Application Ref: H12-1121-25

Proposal: **Proposed vehicular access**

Location: **Villa Farm, Lutton Garnsgate, Long Sutton, Spalding, PE12 9JP**

SITE PLAN - PROPOSED - 1:250

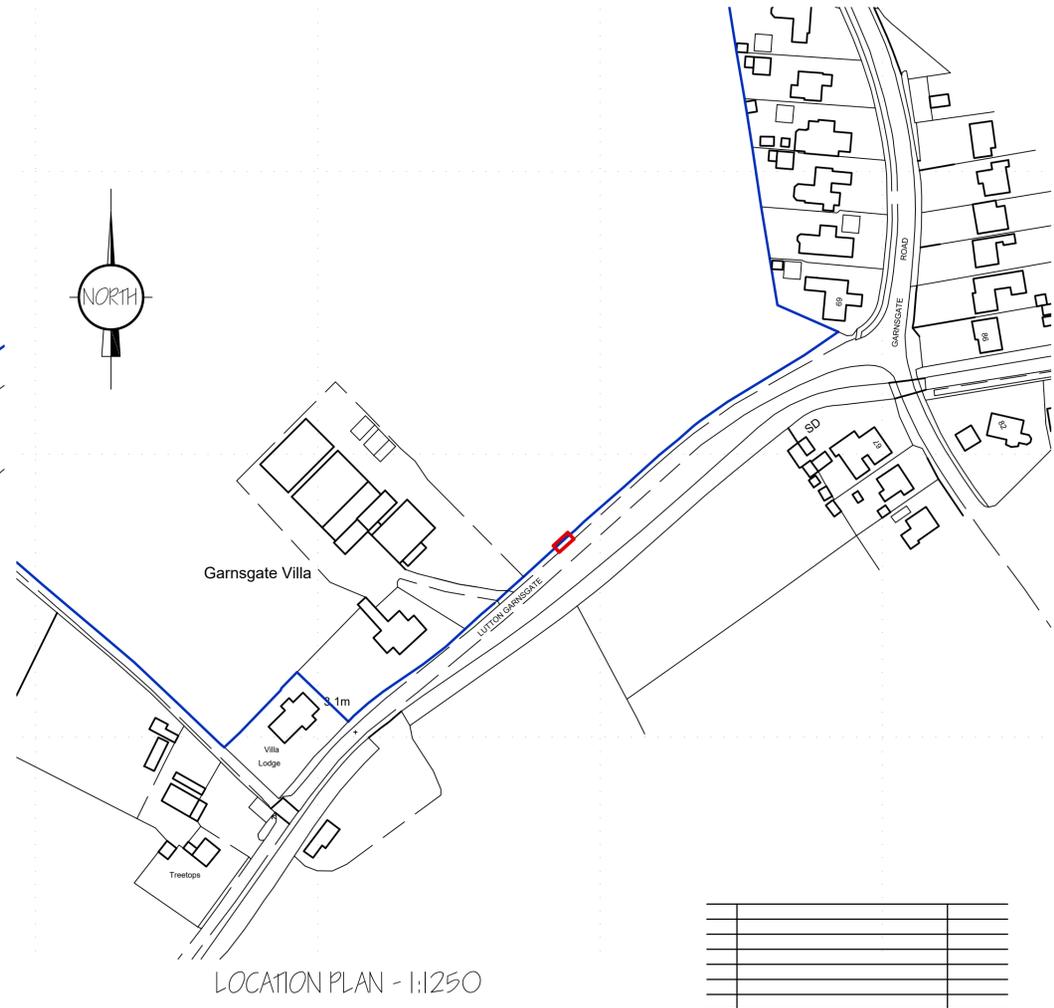
Visibility needs to be demonstrated in accordance with Manual for Streets.

A note should be added to the proposed site plan to say that the access will be constructed to Lincolnshire County Council Specification.
